TOWN AND COUNTRY PLANNING ACT 1990

FULL

Reference: H09-0627-25 **Date of Decision:** 28th August 2025
Applicant: Mr H Juniper
28 Balmoral Way
Holbeach
Spalding
Lincolnshire
PE12 7RP
Location: 28 Balmoral Way Holbeach Spalding
Description: Proposed extension to dwelling to form bedroom and en suite above former garage

SCALE 1:50
SCALE 1:1

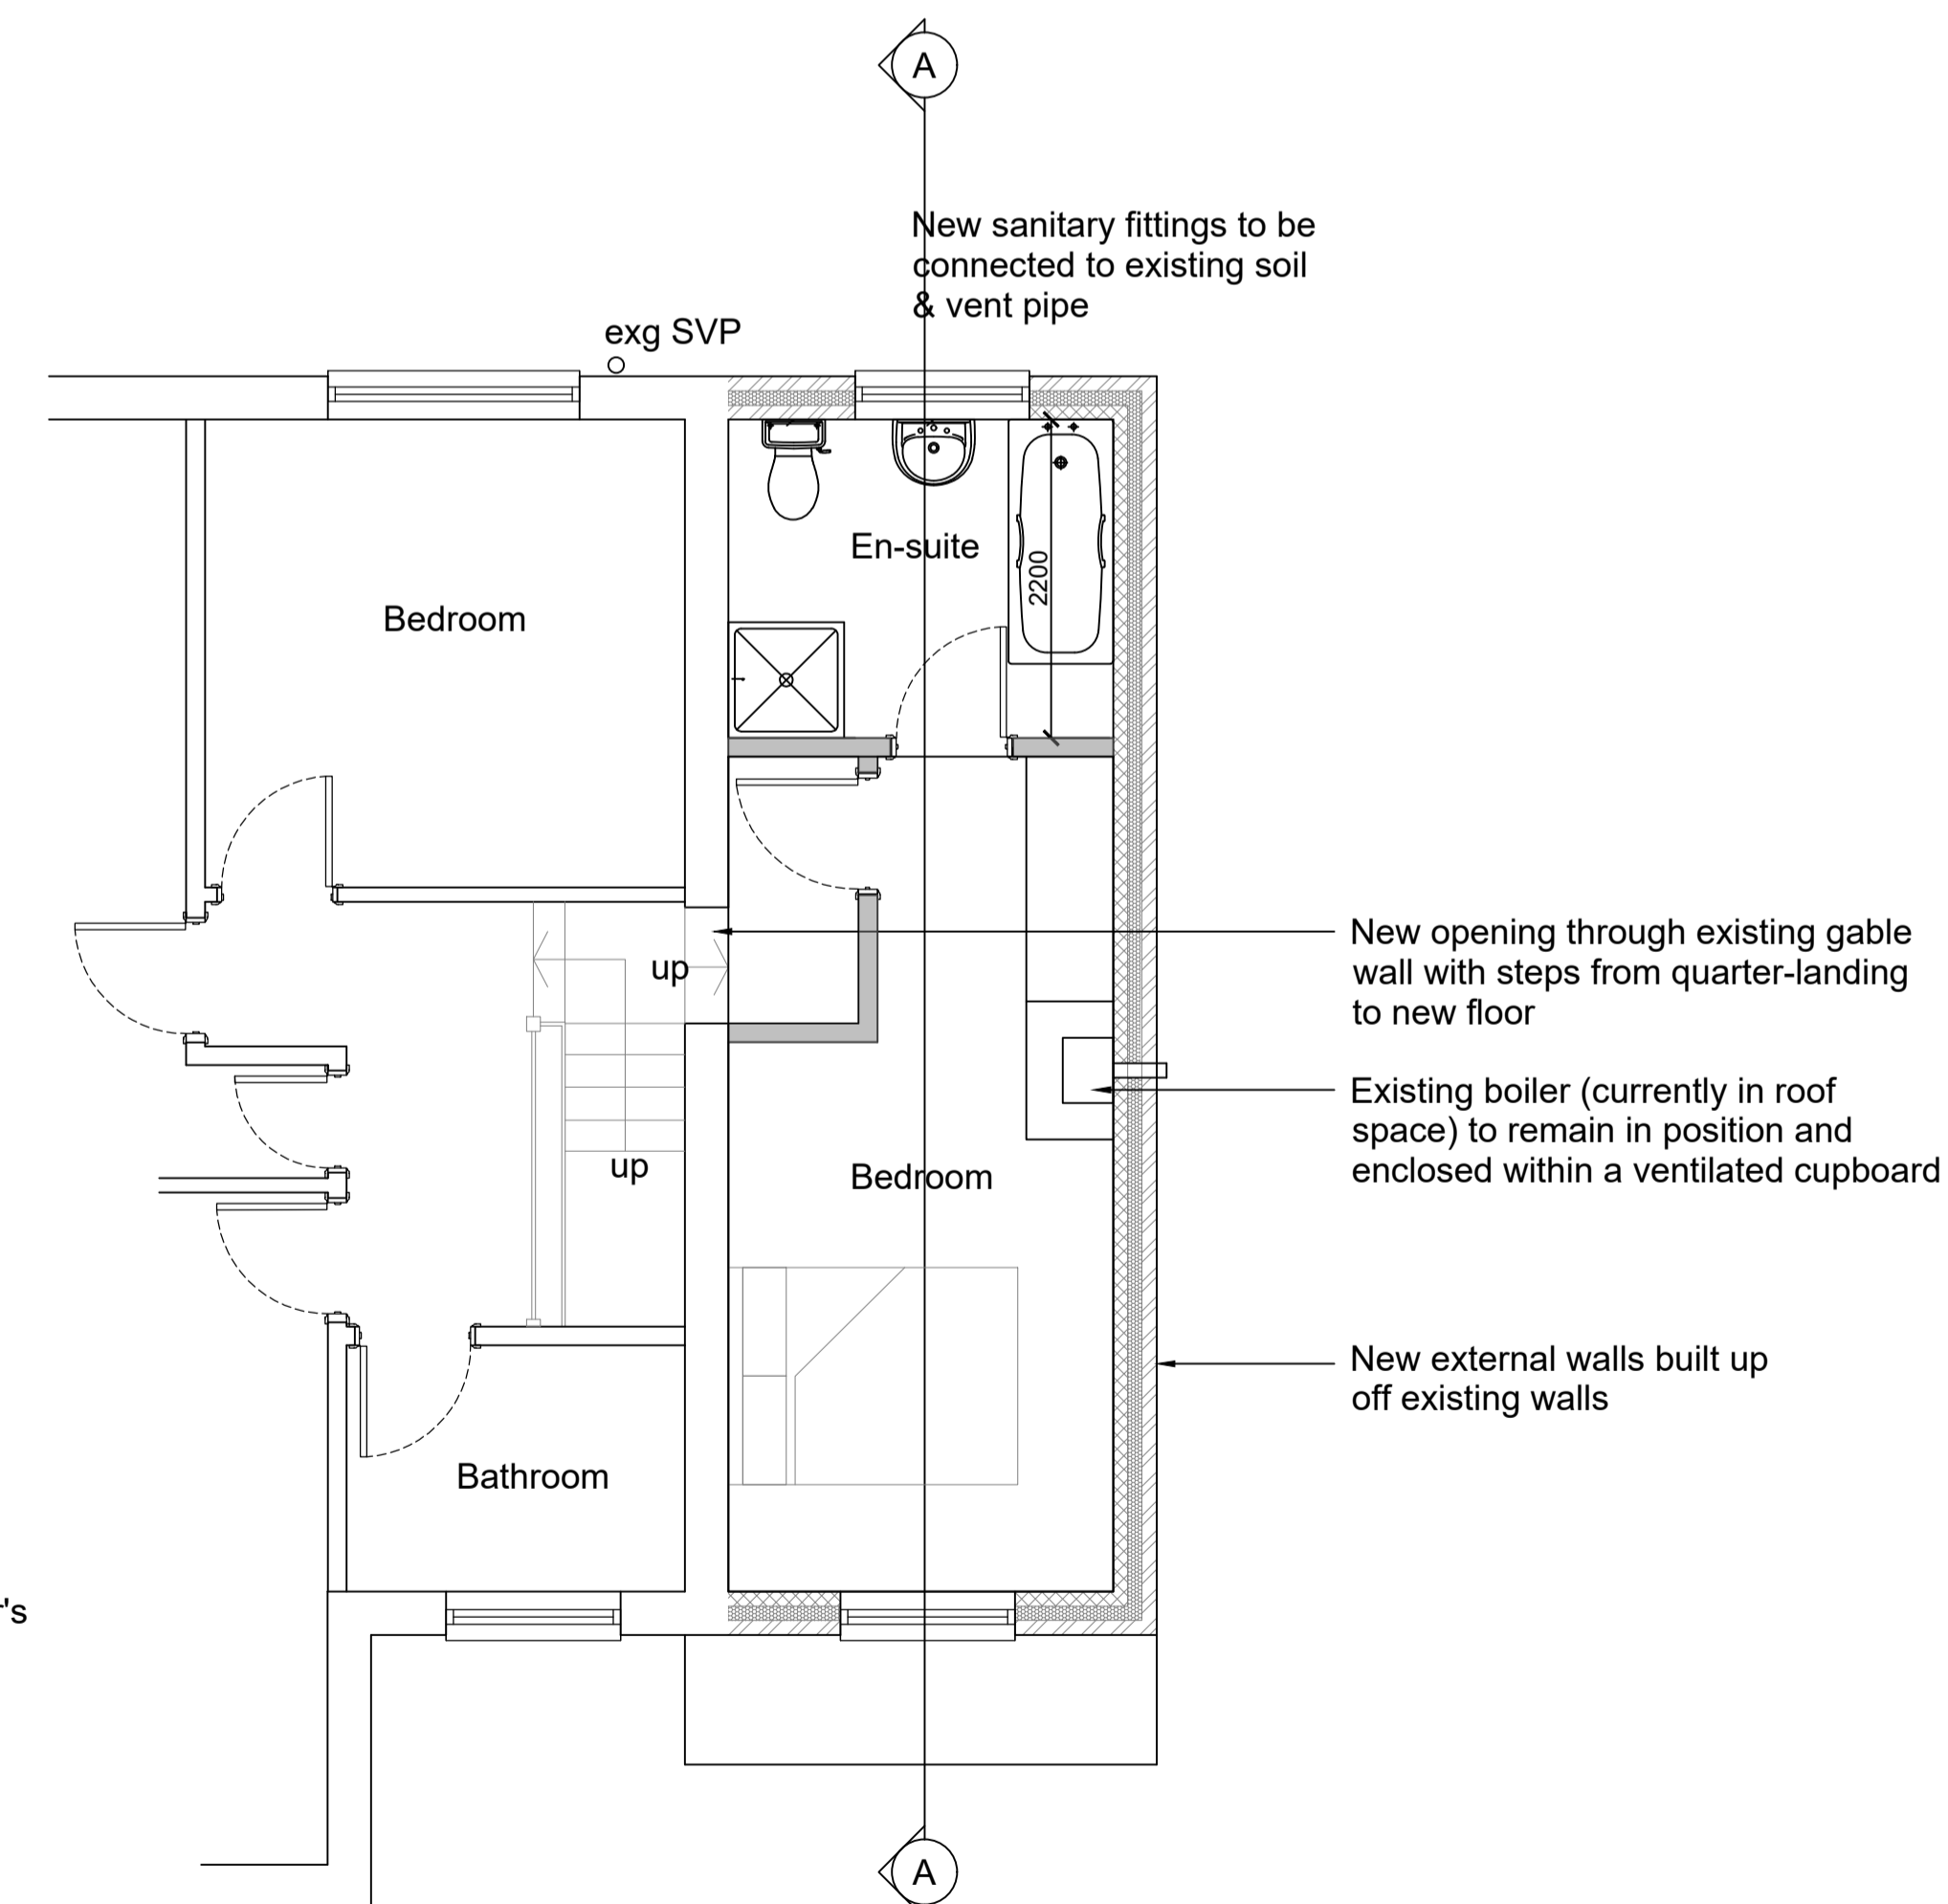
- 4 Notwithstanding the details submitted, before any part of the development hereby permitted is occupied, the following window(s) shall be installed with obscure glazing (to a minimum level of Pilkington - Privacy Level 3 or an equivalent product) and shall have no opening part being less than 1.7m above the floor level immediately below the centre of the opening part.

- Rear en-suite window

Once installed, the window shall thereafter be retained as such.
